City of Albuquerque Stormwater Construction Site Inspection Report

Project Name and Location	Chedden's Casual Cafe Randy Hayden 4865 Pan American Rwy NE		
Site Contact Name & Agency	Randy Hayden South Fork Construction	Contact Phone #/ E-mail	214 596-6708
Date of Inspection	1-17-17	Start/End Time	9:10/9:15
Inspector Name, COA Dept.	Curtis Cherne, Stormwater Quality		
Inspector Phone / E-mail	505-924-3420/ccherne@cabq.gov		
Inspector Qualifications	Qualified Compliance Inspector of Stormwater- Stormwater One		
Describe Present Phase of Construction	Stabilized

**Re: Erosion and Sediment Control Permit F17E006-OP -Cheddar's Casual Cafe
Permit Compliance Inspection**

TEMPORARY SWALE DETAIL SECTION A-A

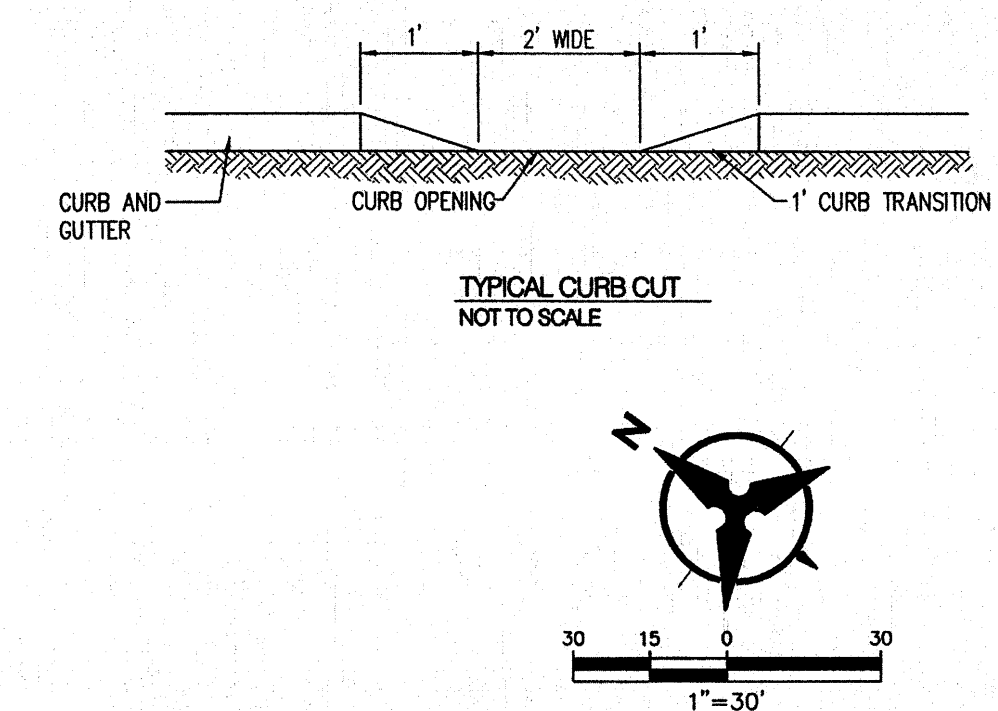
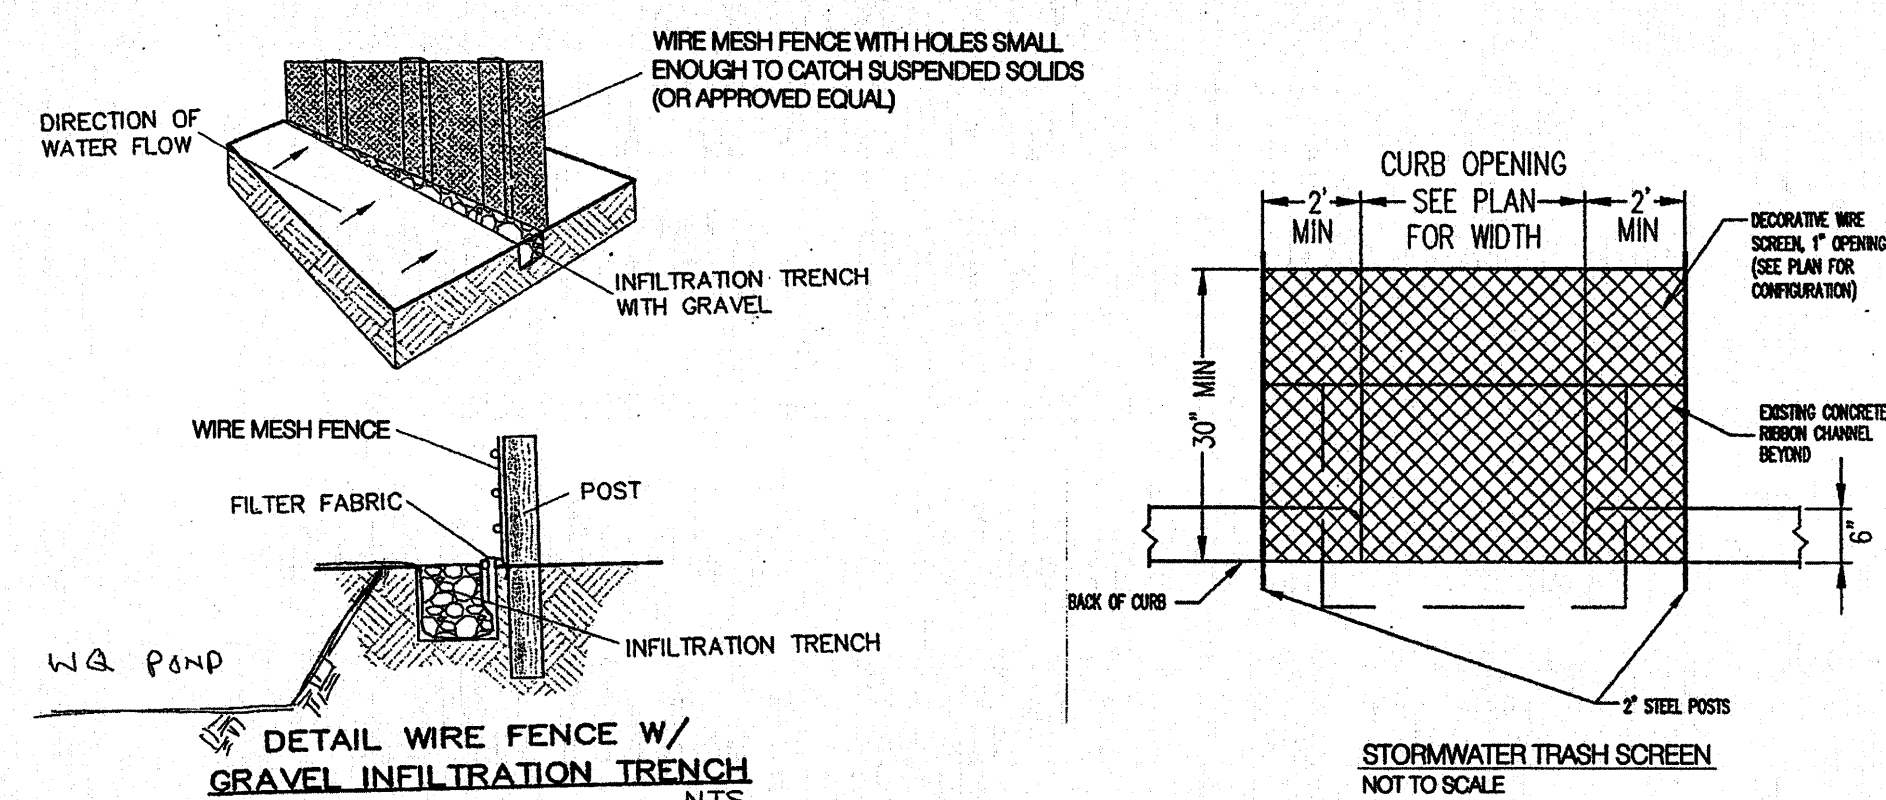
7. Runoff from the site along the southern boundary (PNM site) may leave the site east of the outfall location and erode under the silt fence. A swale should be graded or a berm constructed. A berm was shown on the approved grading plan.
